May 2, 2018
File No. 14-206.200

**Subject: Additional Geotechnical Recommendations and Plan Review
Proposed Single-Family Residences
8375, 8379, 8383 East Mercer Way, Mercer Island, Washington**

We reviewed the geotechnical engineering aspects of the current civil design plans for the above-referenced project. The plan sheets we reviewed included plan sheets C0.0 through C8.0 dated April 4, 2018 by Civil Engineering Solutions. In general, based on our review of the current plans, it is our opinion that the civil plans are in general accordance with the geotechnical recommendations presented in our revised geotechnical report dated February 4, 2016.

TOPOGRAPHIC SURVEY  
 NW 1/4, NW 1/4, SEC 31, T 24N, R 5E, W.M.  
**RUN YONG USA**  
 8375 & 8383 E MERCER WAY  
 MERCER ISLAND, WA

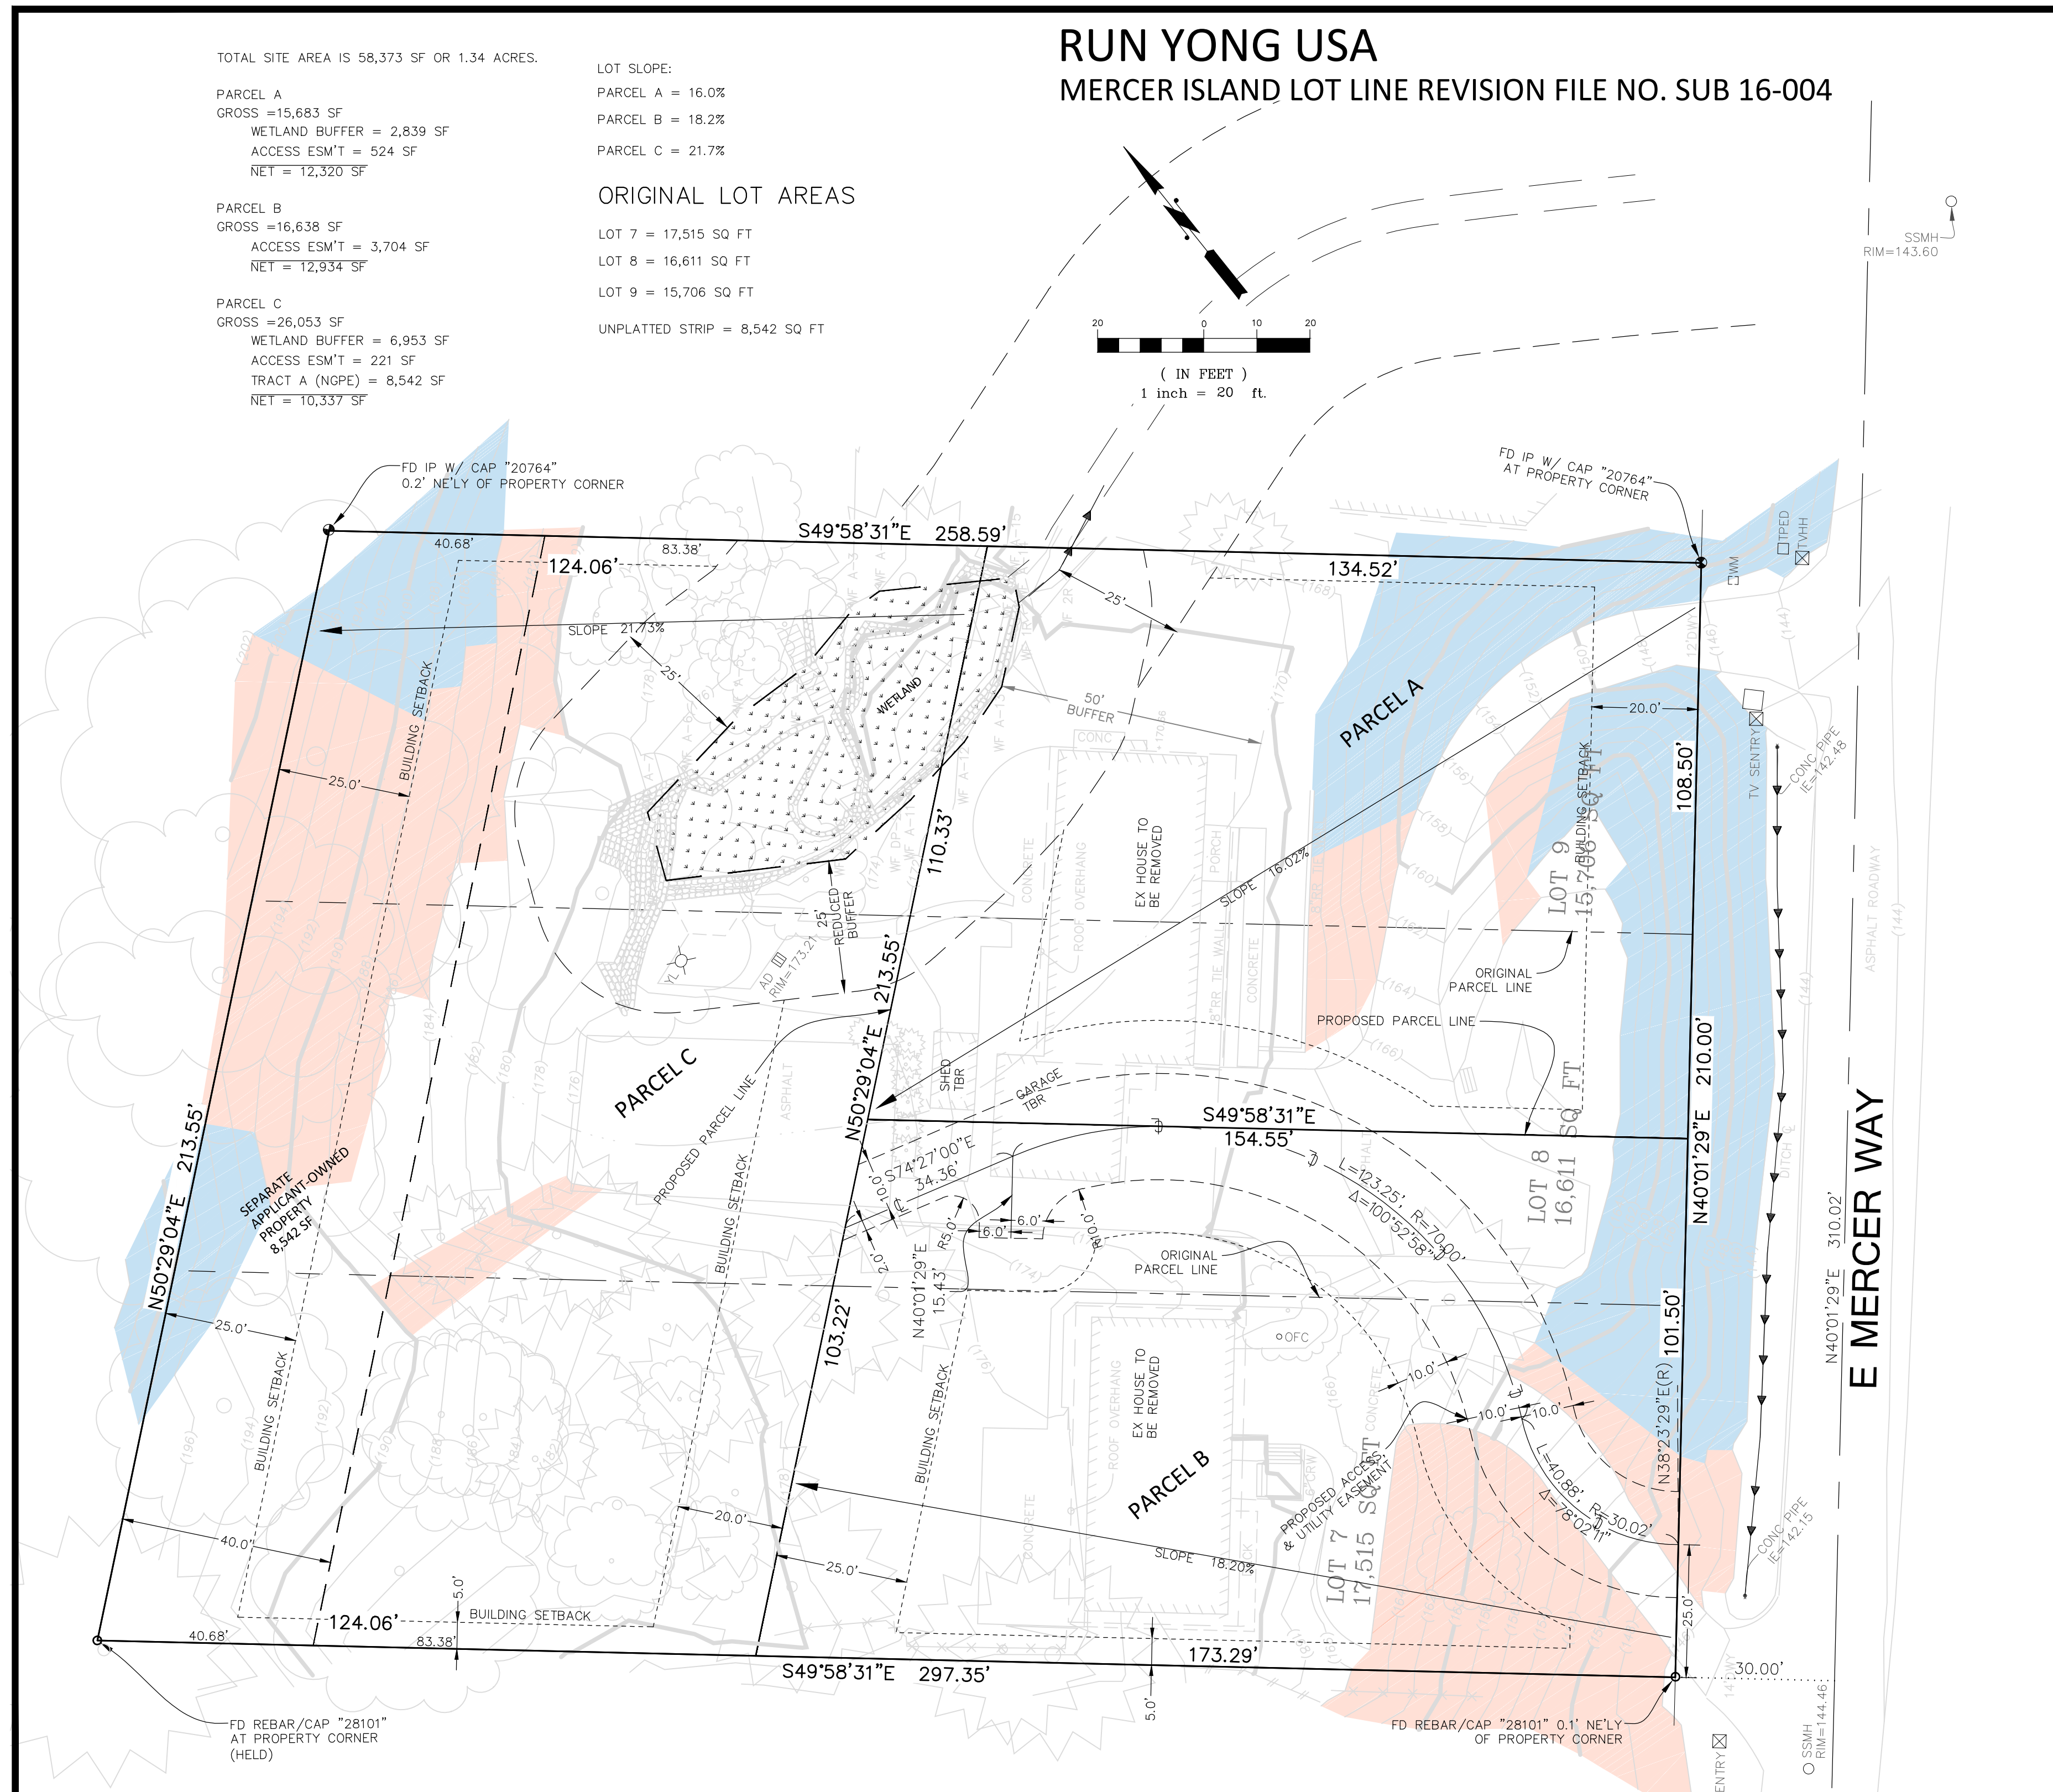
The topographic survey map indicated that several slope areas in the eastern portion of the site are steep slopes (40% or greater). Based on the site soil conditions at the site, presence of roadway and driveway, and other landscape features, it is our opinion the steep slopes are caused by grading of the roadway and driveway, and should be considered man-made steep slopes (artificially created cut slopes). As such, it is our opinion that these slope areas do not meet the definition of “Steep Slopes” per MICC 19.16.
